DRB CASE ACTION LOG (PREL/FINAL)

DRB	Application No.: 08DRB-70003 Project # 1006004 / 1005355
Proje	ct Name: BULK LAND PLAT FOR MESA DEL SOL INNOVATION PARK II
Agen	t: BOHANNAN HUSTON INC. Phone No.: 名23-10分
follov	request was approved on ፫፫- ዕዛ-ዕ <u>ዓ</u> by the DRB with delegation of signature(s) to the ving departments. STANDING SIGNATURES COMMENTS TO BE ADDRESSED
	TRANSPORTATION:
	UTILITIES:
	CITY ENGINEER / AMAFCA:
	PARKS / CIP:
	PLANNING (Last to sign):
	1/10 - aminded 1777
	Planning must record this plat. Please submit the following items:
	-The original plat and a mylar copy for the County Clerk.
	-Tax certificate from the County TreasurerRecording fee (checks payable to the County Clerk). RECORDED DATE:
	-Tax printout from the County Assessor.
	 3 copies of the approved site plan. Include all pages. County Treasurer's signature must be obtained prior to the recording of the plat
	with the County Clerk. Property Management's signature must be obtained prior to Planning

Preliminary Final Plat Approval

Replat of Tract Q, Mesa Del Sol Innovation Park II

TRACT Q-3
0.2954 Acres
(SEE NOTES 1, 2
& 3, THIS SHEET)

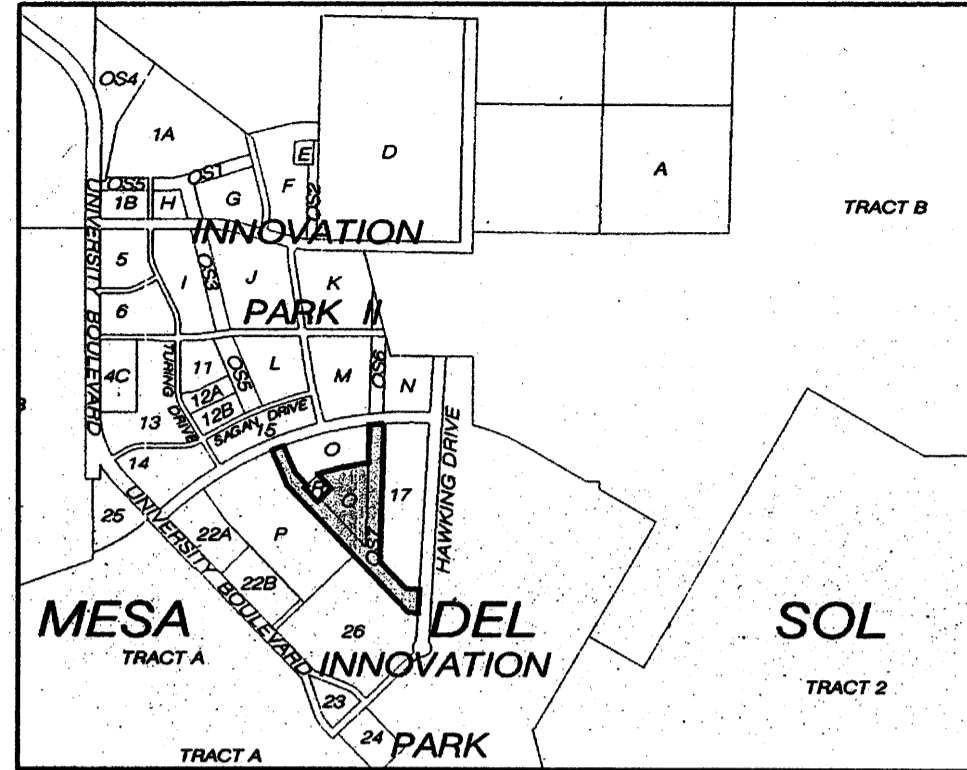
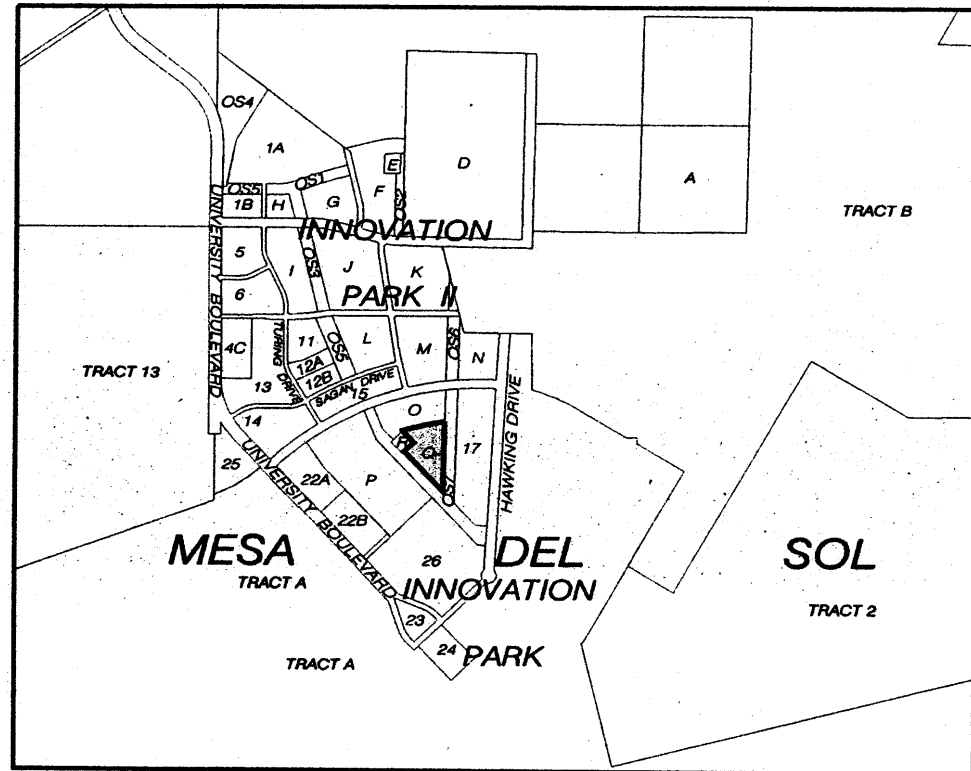
Refer to comments from ABCWUA; there appears to be an undefined easement connecting the southern end of proposed Tract Q-1 to Tract OS-7 (across proposed Tract Q-2).

Status of adjoining/ accessing infrastructure needs to be addressed; if not financially guaranteed, a Bulk Land Variance may be required.
